Engineers Comments Regarding Surface Water Drainage

APPLICATION NO: BN/22/20/PL

Site Address: Land South West of 40 Hill Lane Barnham PO22 0BL

Description of Works: Remove existing polytunnels & creation of sand school with new native tree & hedge planting.

NATIVE PLANTING
Hedging shown green on the plan to consist of a double row of the following native hedging bare root plants 40 – 60cm in height, planted in a random mix.

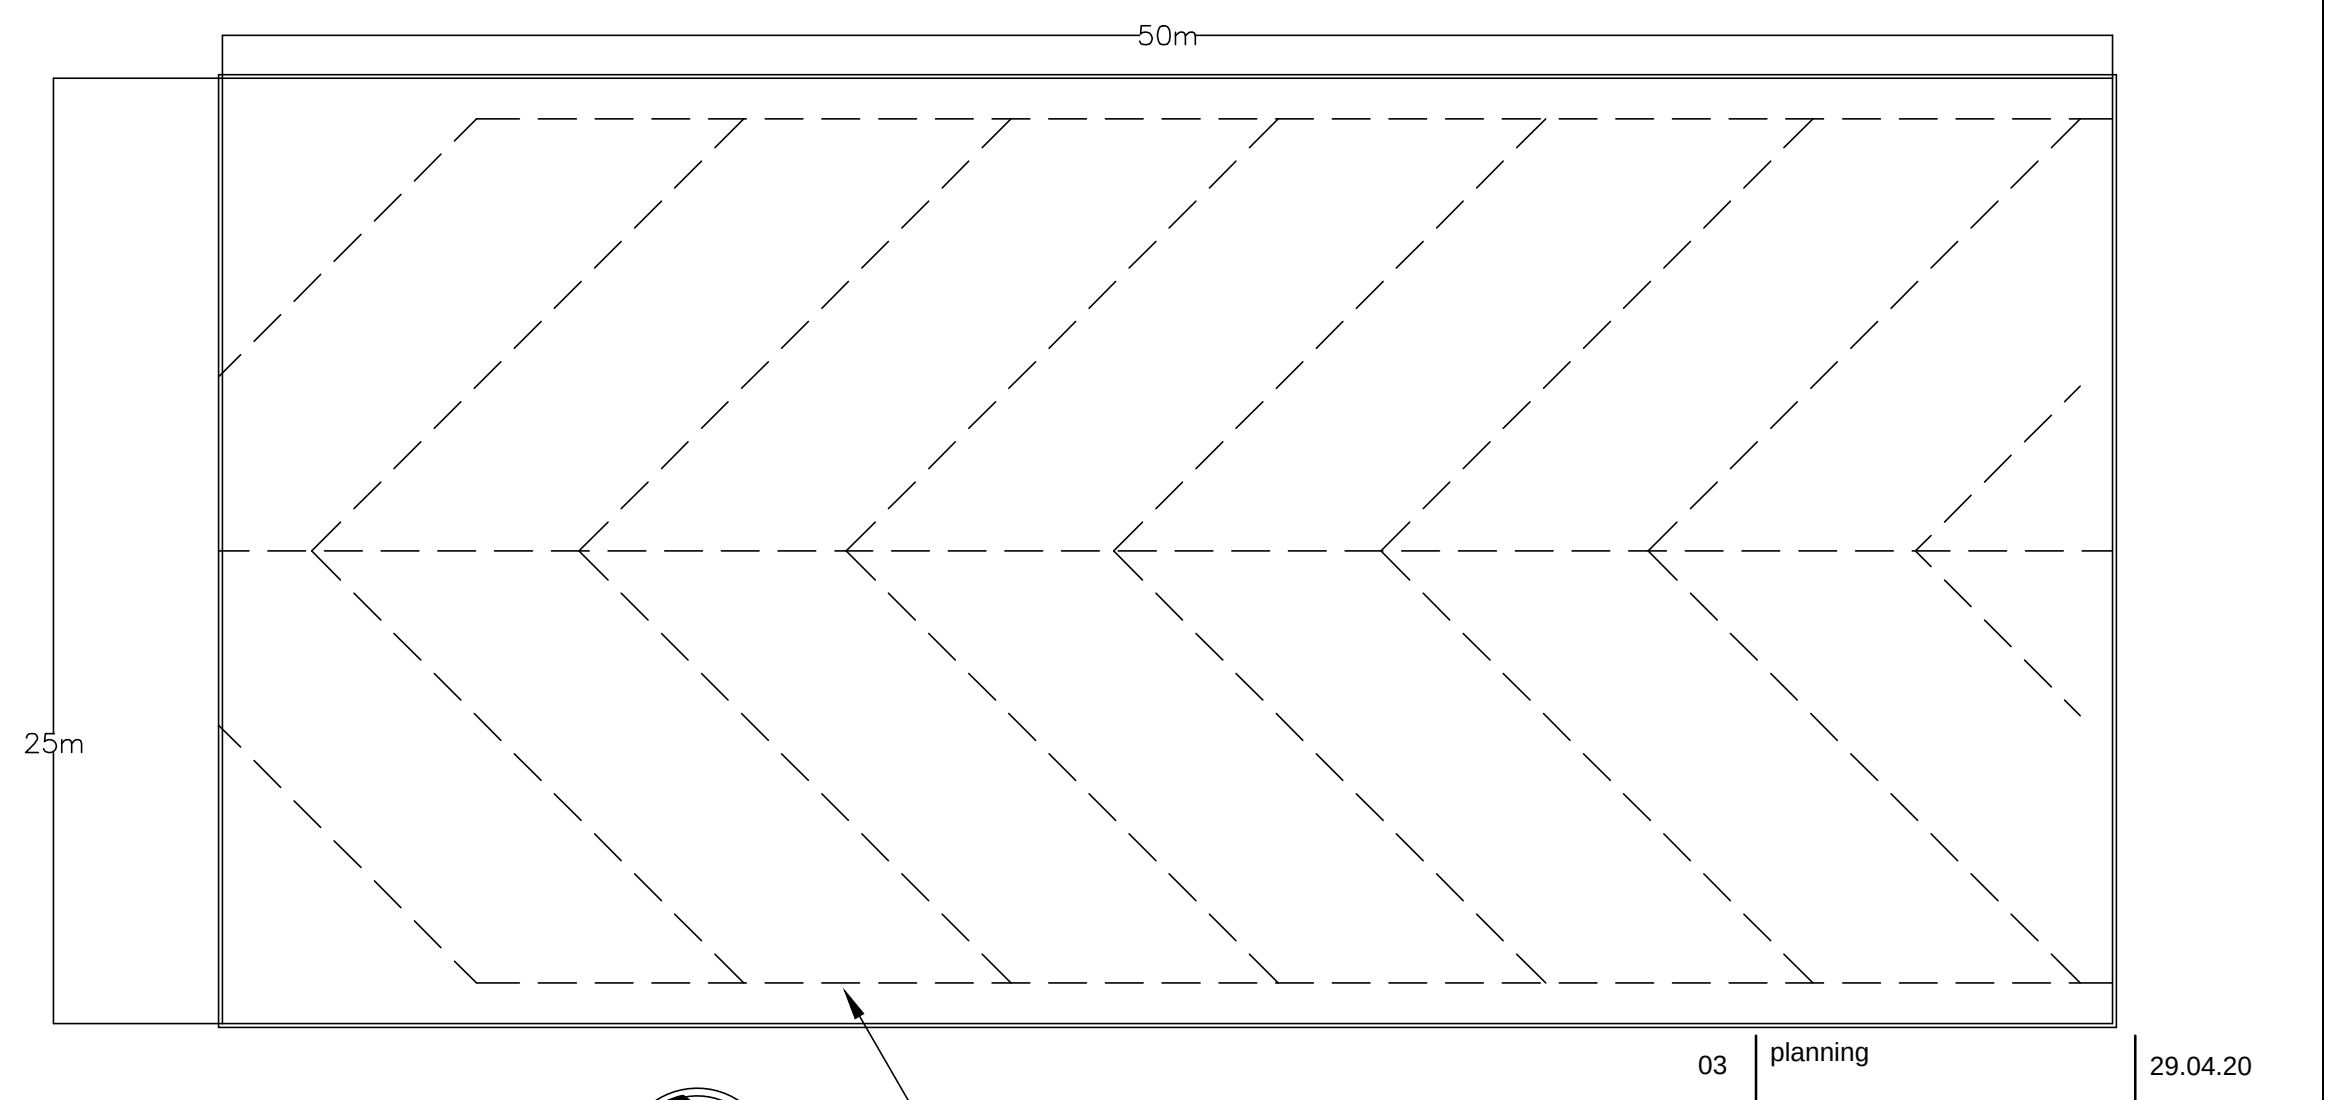
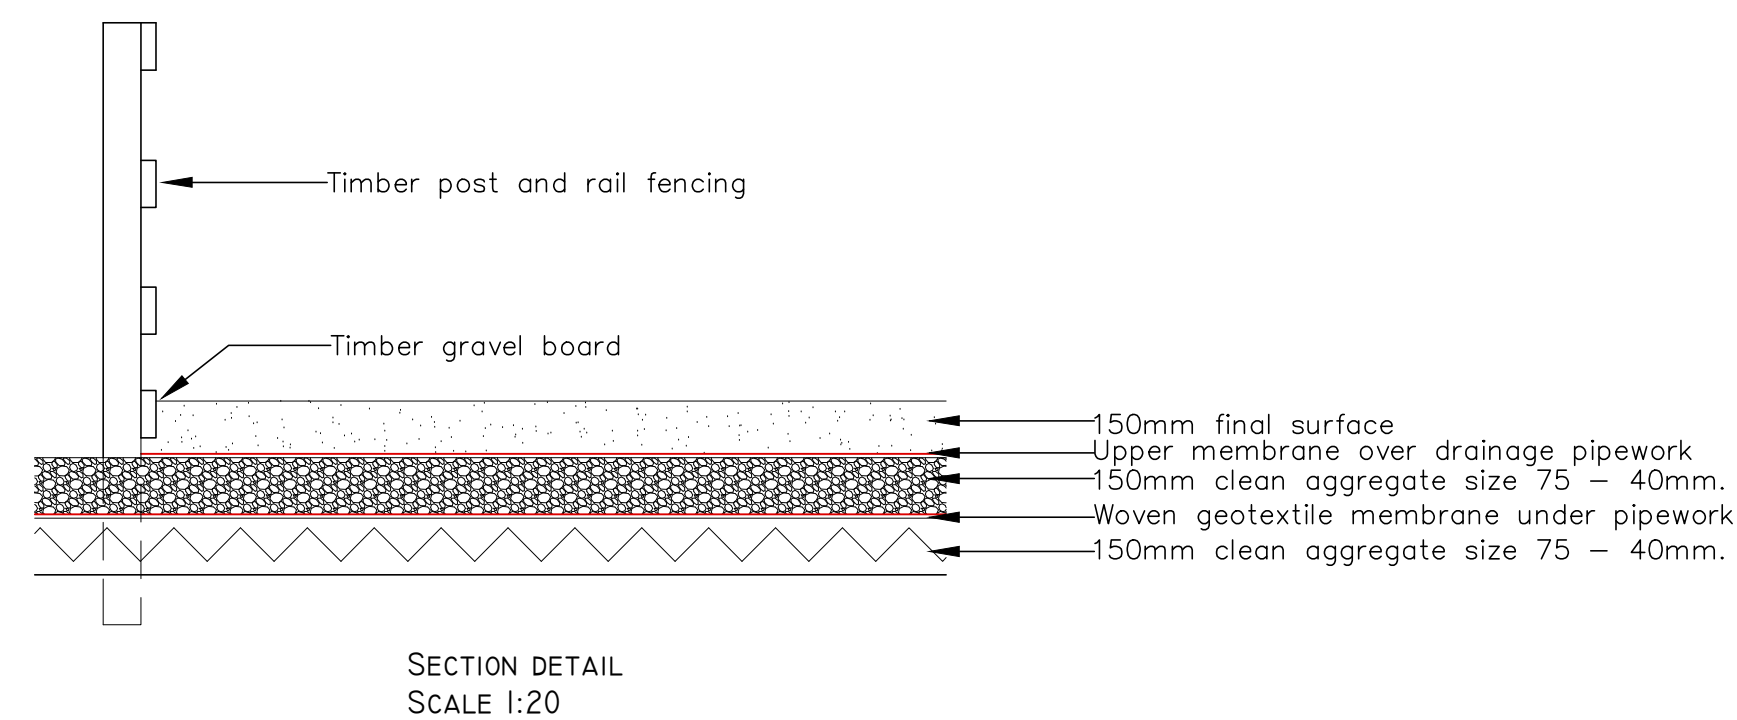
The application is within the Lidsey Treatment Catchment, therefore surface water drainage design should be carefully considered. The site plan and section detail show a series of perforated pipes with no drainage layout or design to show how the 1250m² training school will be drained. The applicant has stated in the application that the school shall be drained by infiltration under the structure, however no infiltration testing has been completed to show that this is viable and the need for the perforated pipes is questioned if this is the proposed strategy.

In addition, there is a watercourse running along the northern boundary of the site. The proposed planting must not have a detrimental effect on the Hill Lane ditch and culvert. It is suggested that the Tree Officer is consulted to ensure that the proposed species, and their location will not impact upon this drainage network.

"Development shall not commence, other than works of site survey and investigation, until full details of the proposed surface water drainage scheme have been submitted to and approved in writing by the Local Planning Authority. The design should follow the hierarchy of preference for different types of surface water drainage disposal systems as set out in Approved Document H of the Building Regulations, and the recommendations of the SuDS Manual produced by CIRIA. Winter groundwater monitoring to establish highest annual ground water levels and winter Percolation testing to BRE 365, or similar approved, will be required to support the design of any Infiltration drainage. No building / No part of the extended building shall be occupied until the complete surface water drainage system serving the property has been implemented in accordance with the agreed details and the details so agreed shall be maintained in good working order in perpetuity."
